Application by Highways England for an Order Granting Development Consent for A428 Black Cat to Caxton Gibbet Improvements

The Examining Authority's written questions and requests for information (WQ1)

Issued on Friday 20 August 2021 (advance copy issued on Wednesday 21 July 2021)

Drawing file: TR010044 / TR010044-000261-TR010044_A428_Black_Cat_to_Caxton_Gibbet_Improvements_6-2_Environmental_Statement_Figures_Figure_5-3.pdf

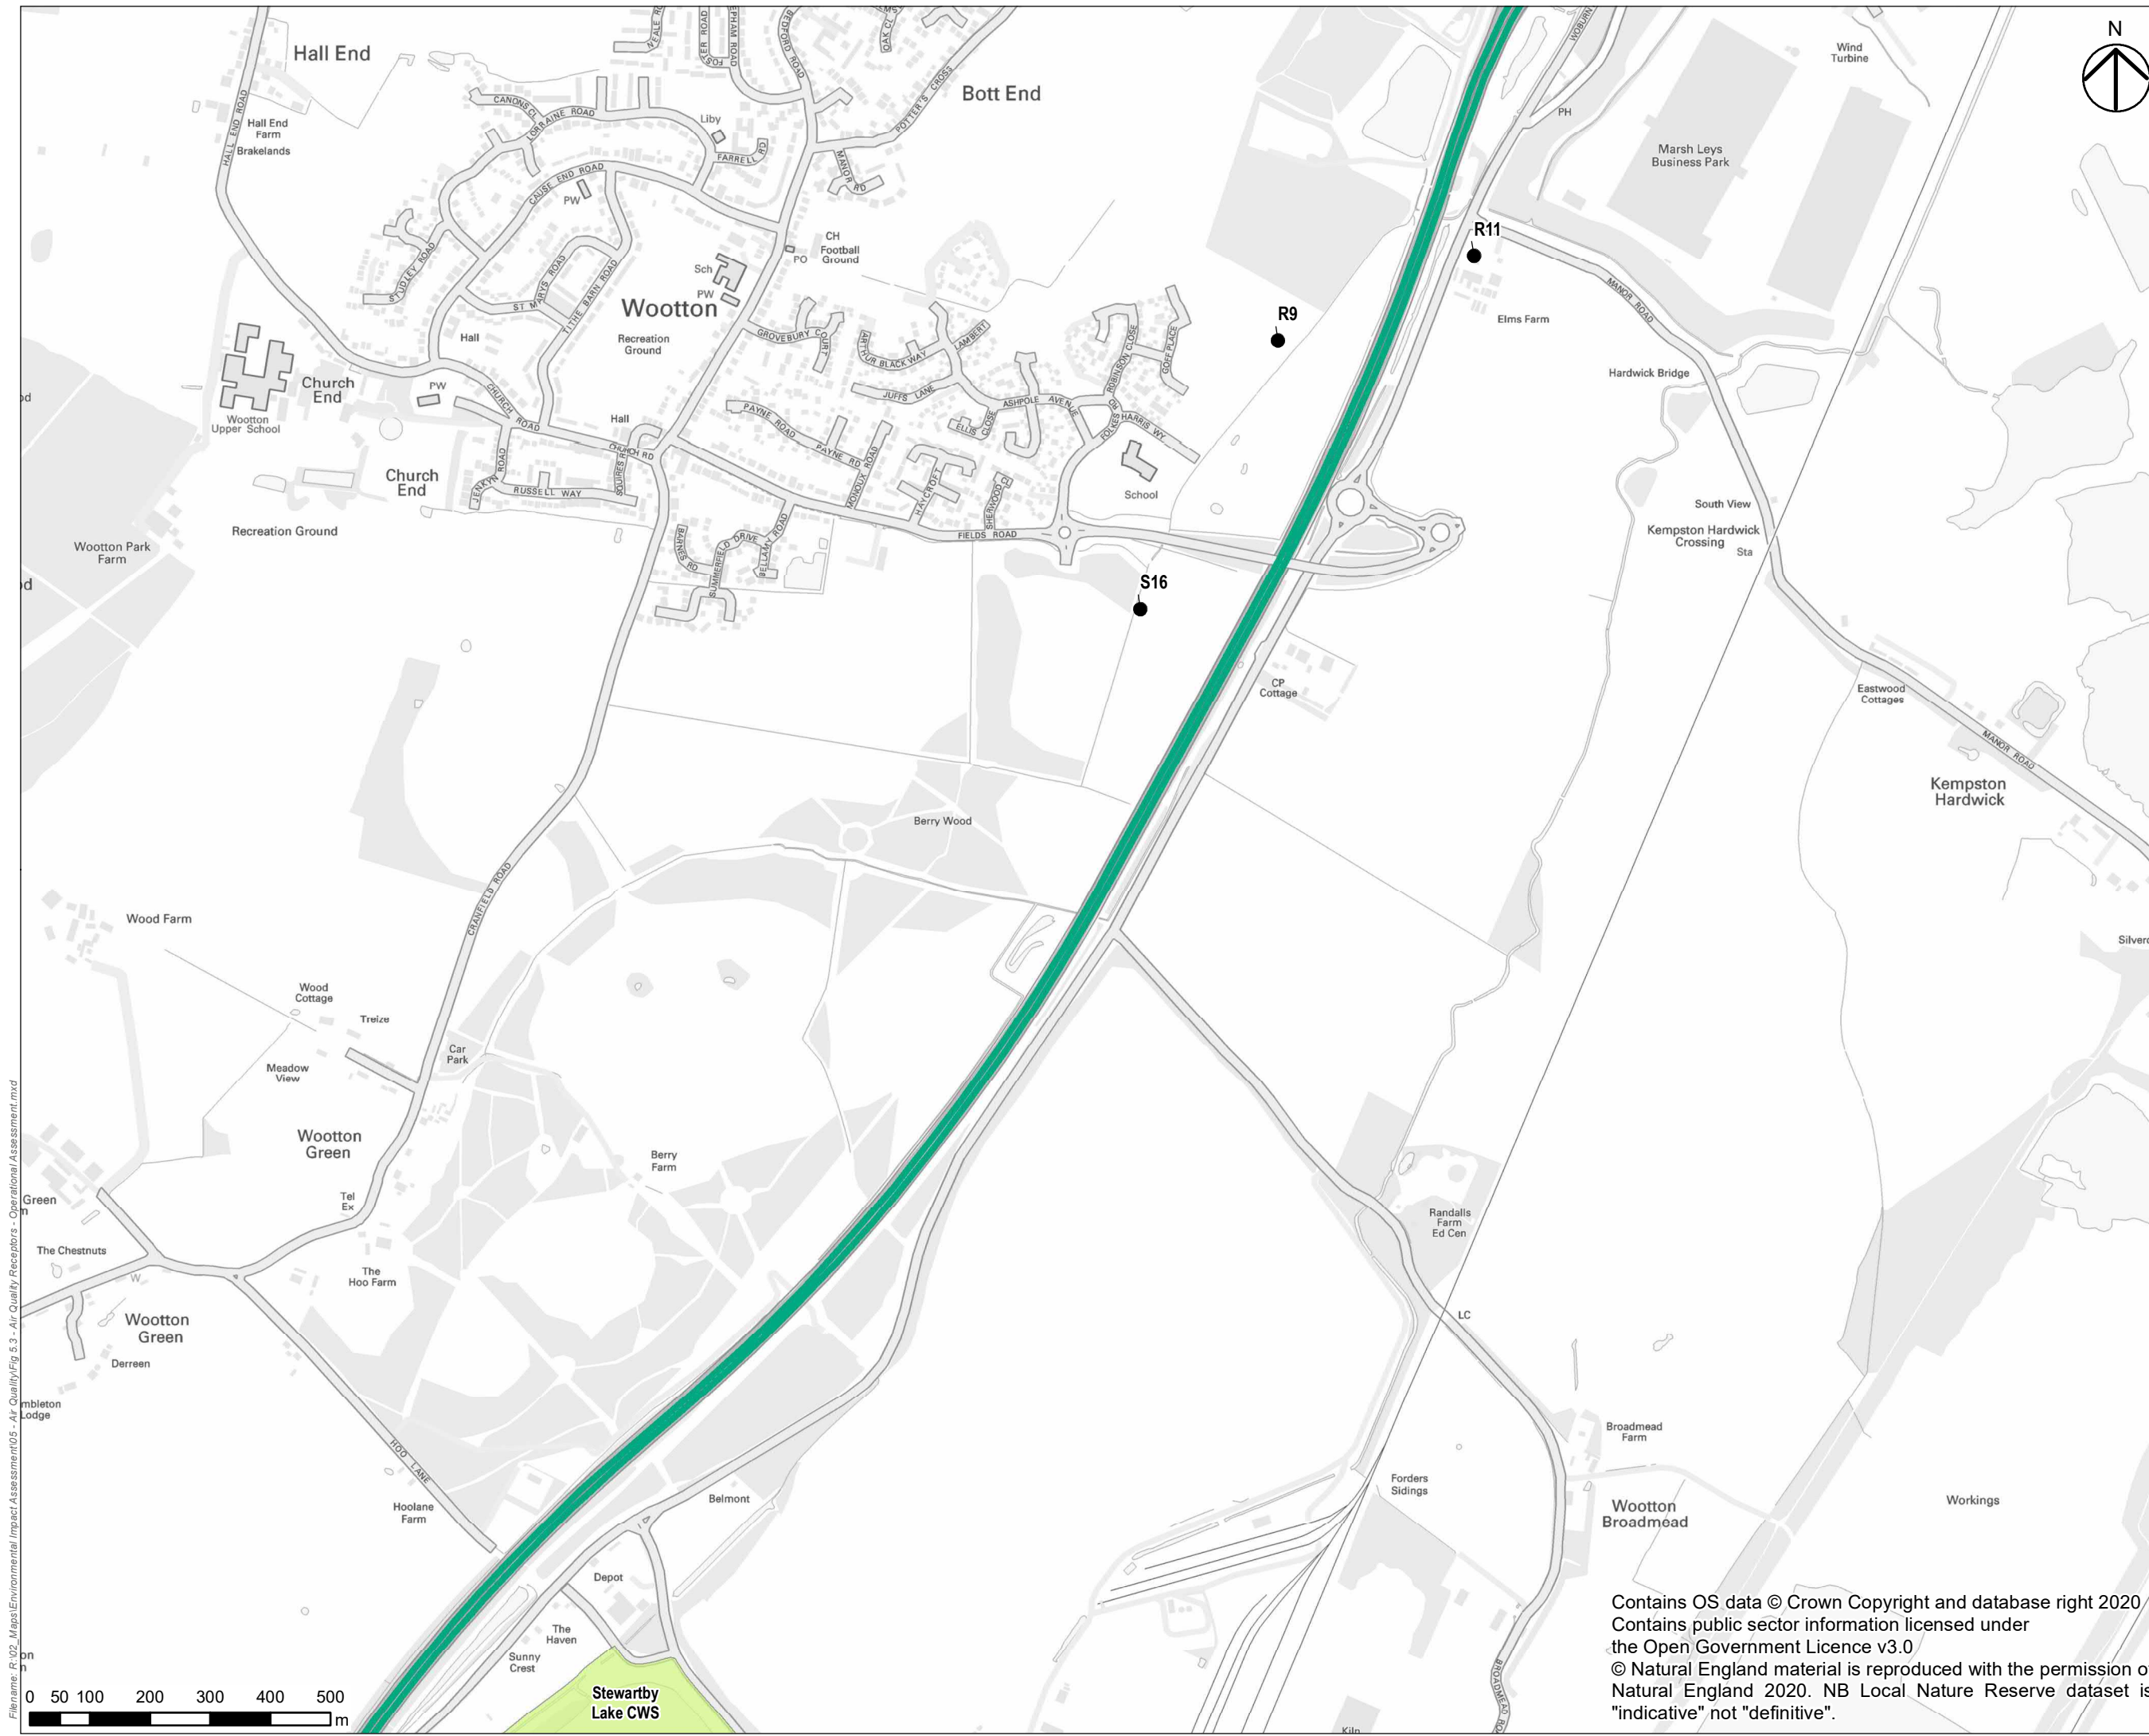
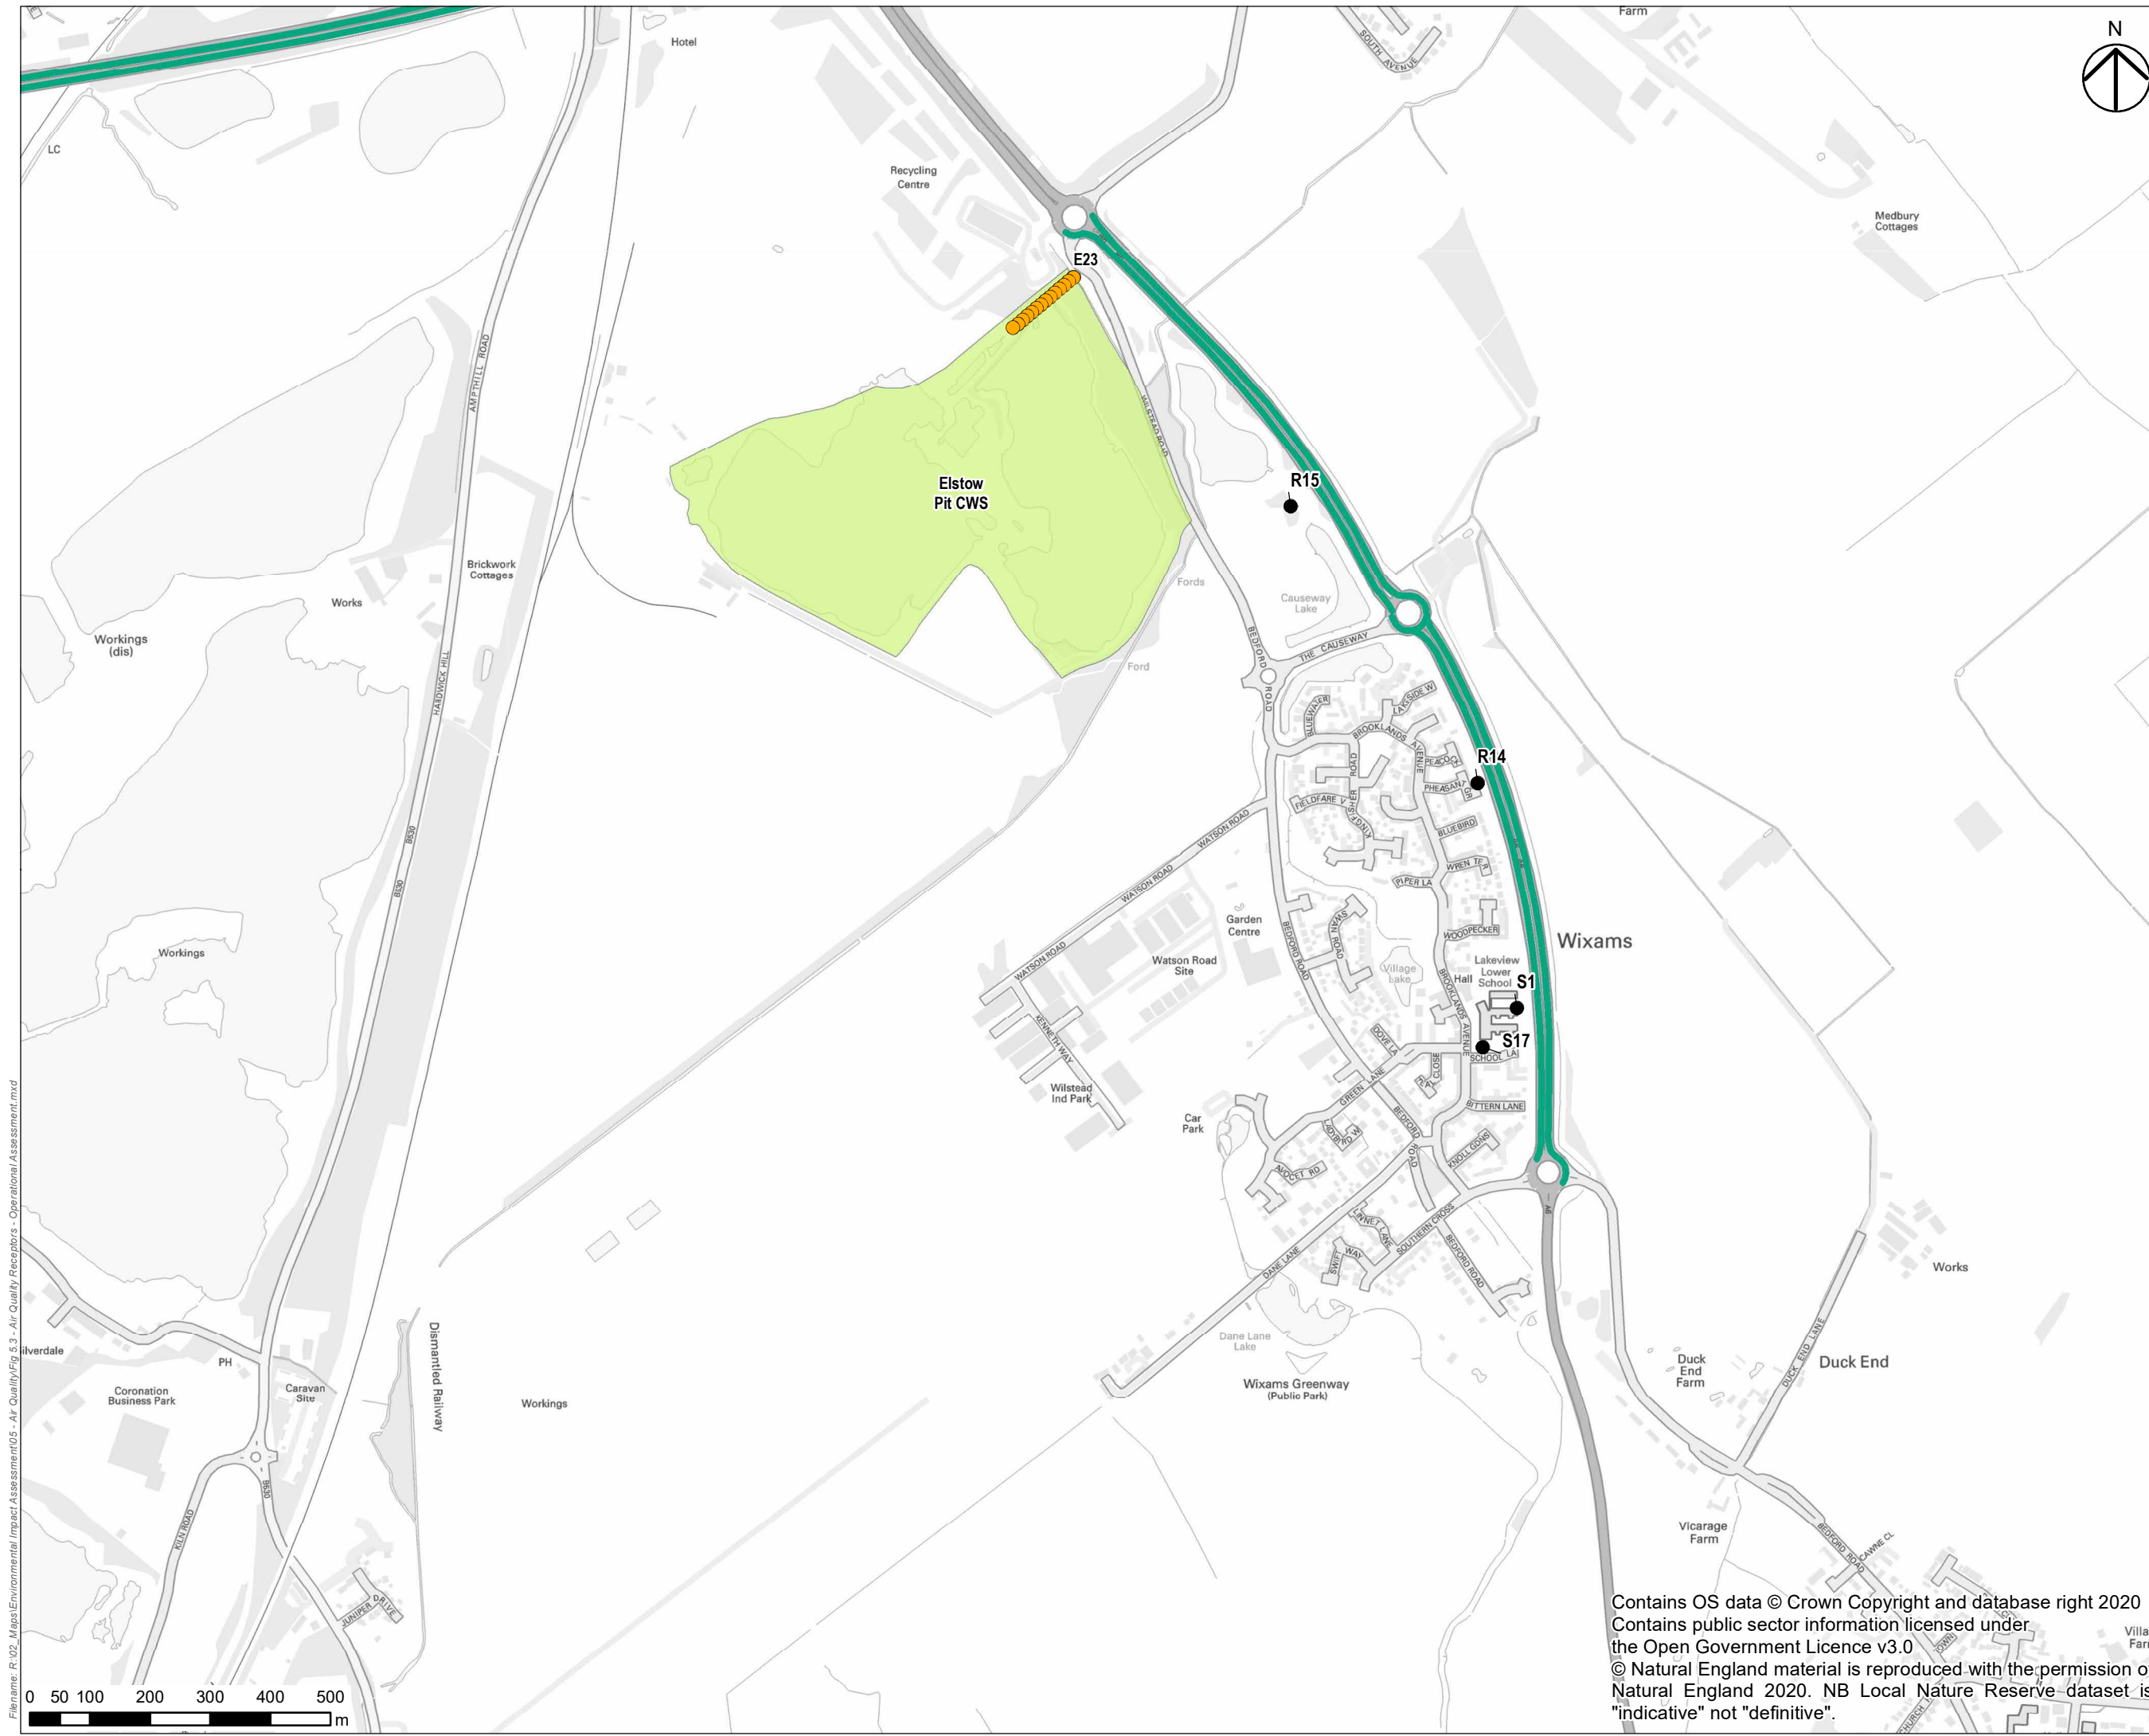
| Q1.1. General and Cross-topic Questions | | |
|---|--|---|
| Q1.2.1.1 | Local Authorities Public Health England | <p>Effects on receptors</p> <p>ES [APP-074, paragraphs 5.9.38 – 5.9.40] states that the Proposed Development would have no significant adverse effects on human health or designated habitats sites during either construction or operational phases of the scheme. Do LAs and PHE agree with this conclusion? Explain with reasons.</p> |
| Q1.2.1.2 | Central Bedfordshire Council | <p>Sandy Air Quality Management Area</p> <p>ES [APP-074, paragraphs 5.9.12–5.9.13] states that the magnitude of NO₂ change is predicted to be imperceptible at the 7 identified receptors in Sandy.</p> <p>a) Does CBC agree with this assessment? If not, explain with reasons.</p> |

| | | b) Are there other design options or measures that should be considered to improve air quality at this location? |
